CITY OF ALBUQUERQUE

**Re: QuikTrip Store #7001- 521 Unser Blvd NW
Traffic Impact Study (K10D071)**
Engineer's Stamp DRAFT dated September 2024
Via email jkruse@lee-eng.com

The subject Traffic Impact Study (Study) received on October 4th, 2024 and the Traffic Study Comment and Access letter (Letter) dated September 18th, 2024, have been reviewed by the City of Albuquerque Planning Development Transportation Section. The City has the following comments/responses/discussion.

SHEET TITLE:
SITE PLAN

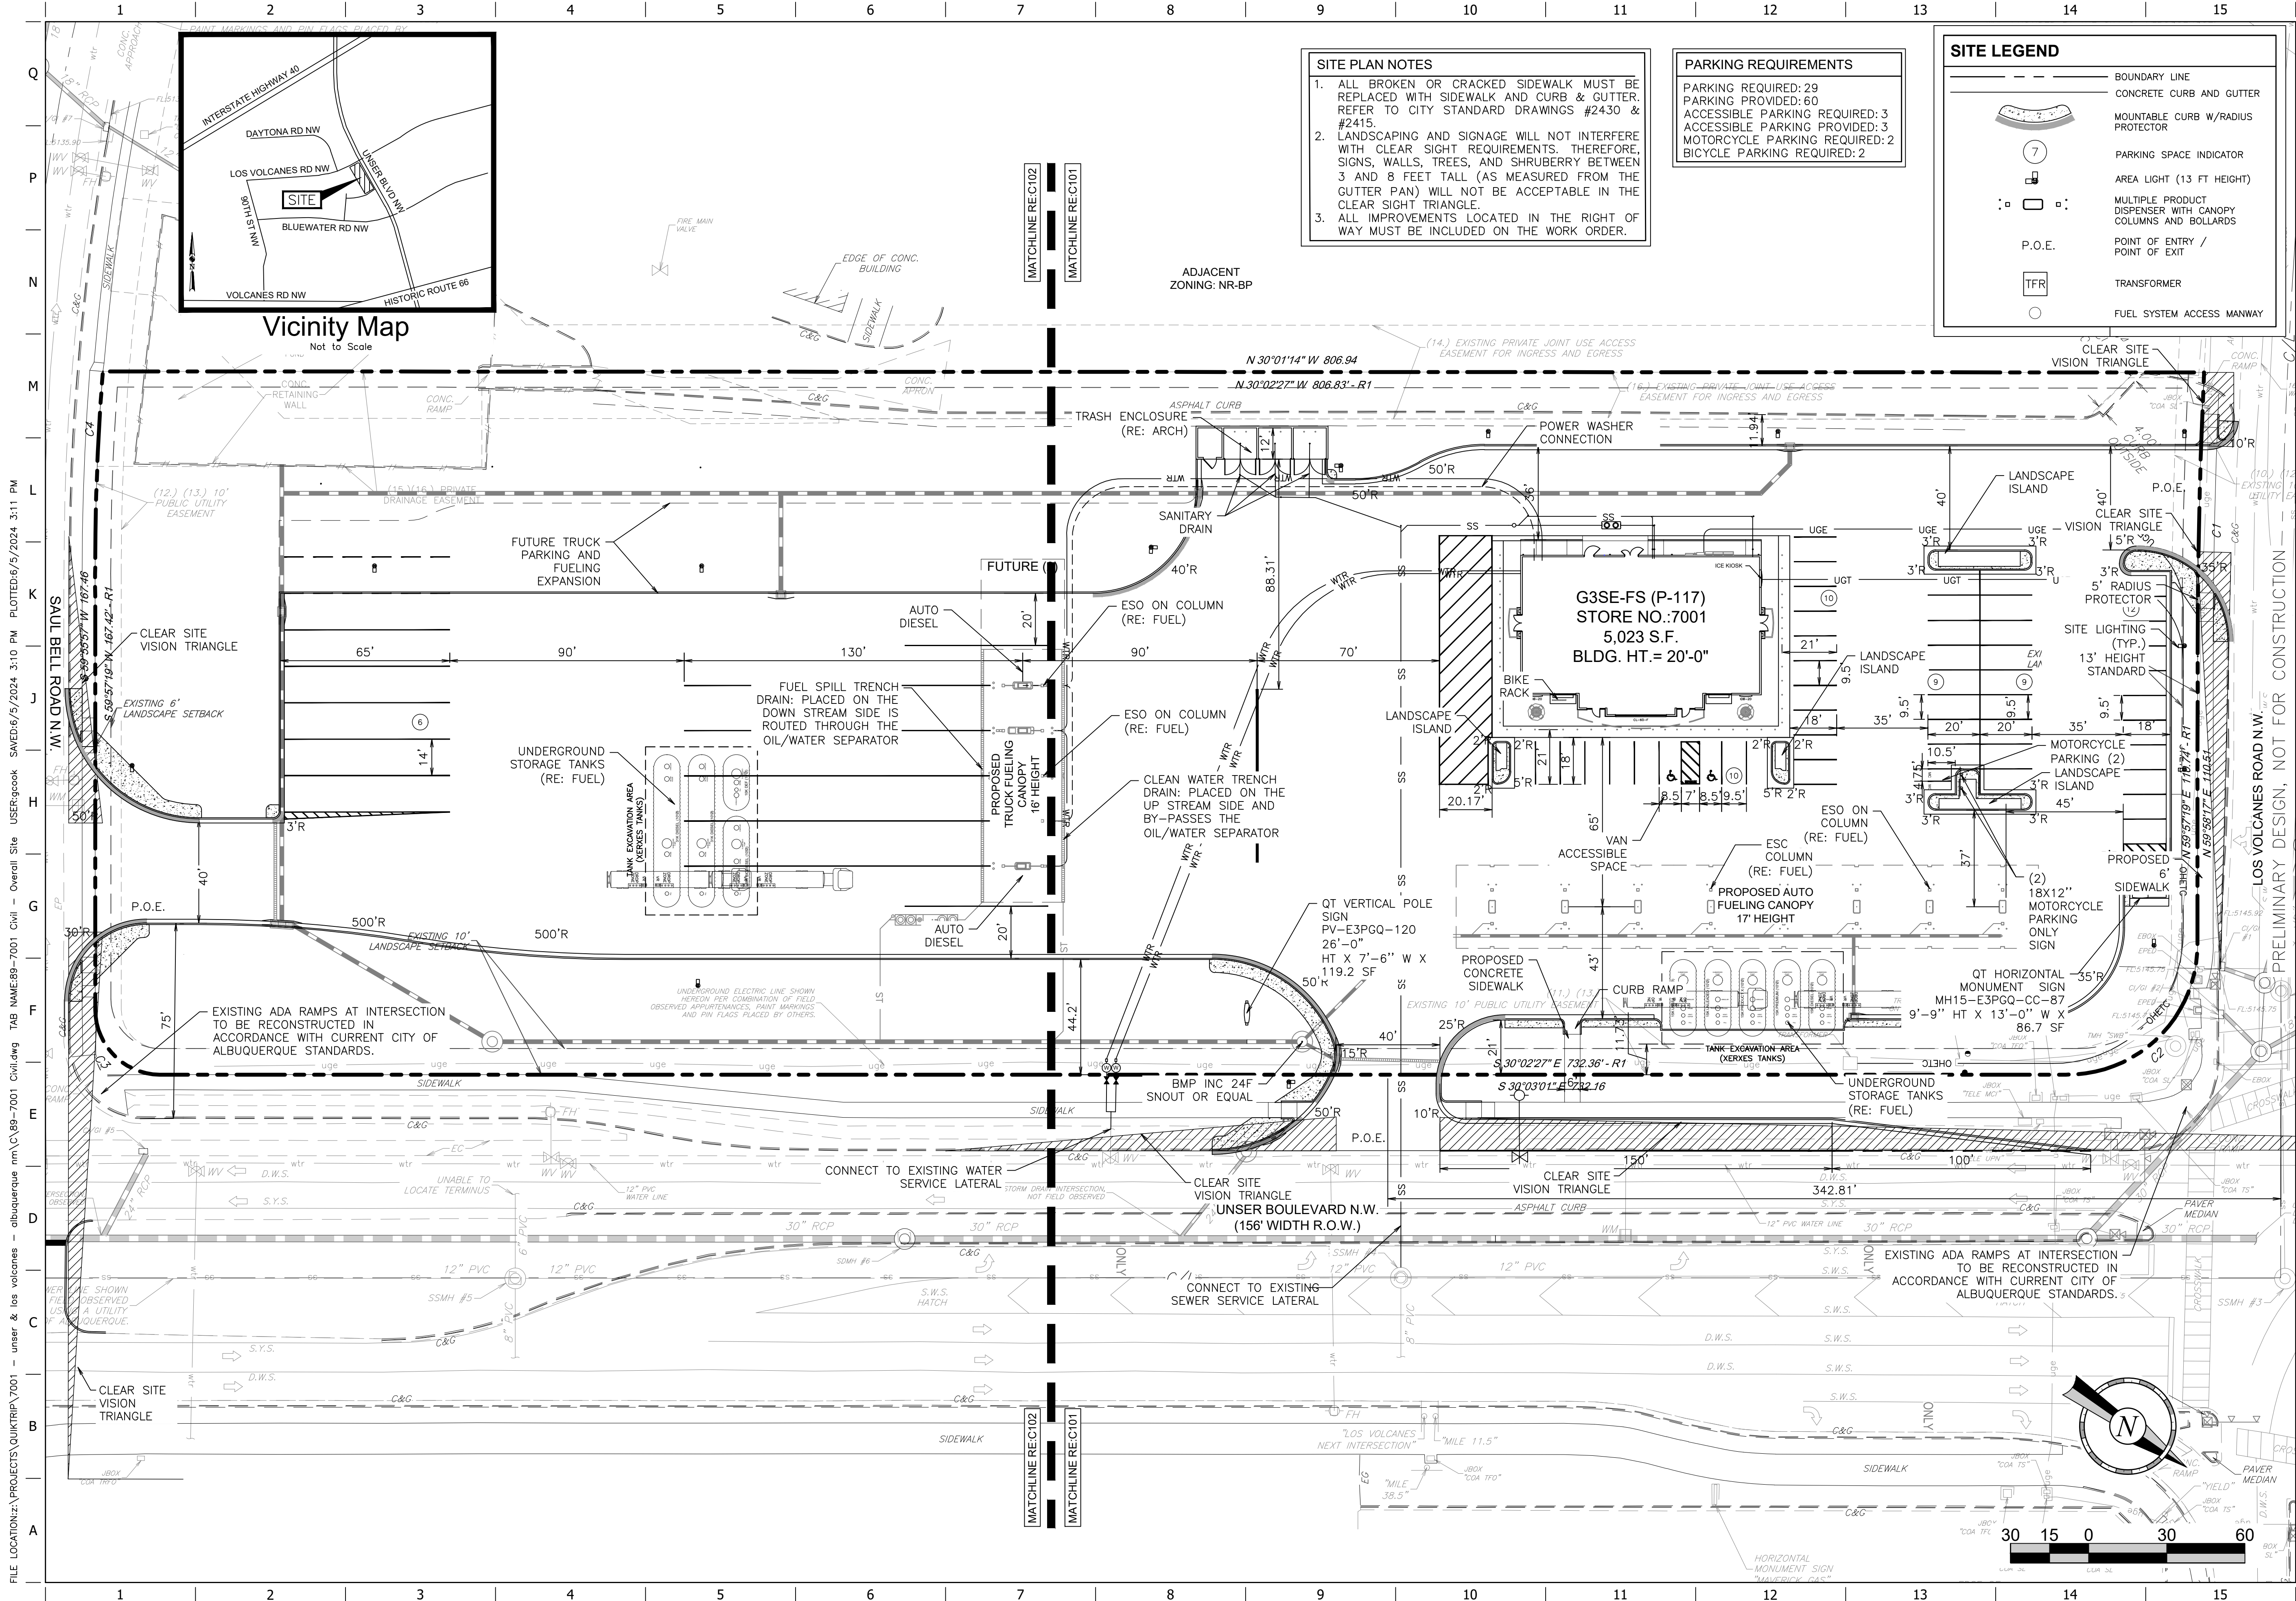
1. Unser Blvd is a Limited Access Roadway and therefore the driveway on Unser Blvd, Driveway 2, is not allowed. **Comment discussed, but not accepted and discussed above.**

2. Site access is to be provided via two driveways: one on Los Volcanes Rd and the other on Saul Bell Rd. **Comment discussed, but not accepted and discussed above.**

3. The driveway on Saul Bell Rd is to be located a minimum of 200 feet from Unser Blvd. It appears the west property line is approximately 285' from Unser Blvd. I am aware of the distances in DPM Table 7.4.45, however, per the Site Plan it appears the tractor trailer entrance is off of Saul Bell and the length of the tractor trailer combined with the reduced speed of leaving the roadway, queuing onto Unser Blvd may occur and should be prevented. **Site Plan not updated. Comment not addressed**

4. Provide a cleaner image of Figure 1: Site Plan. Please include dimensions from the driveway(s) to Unser Blvd. **Site Plan not clear and dimensions not provided. Include a clear Site Plan: minimum size of 11"x17". The Site Plan that was included in the Letter was clear and legible..**
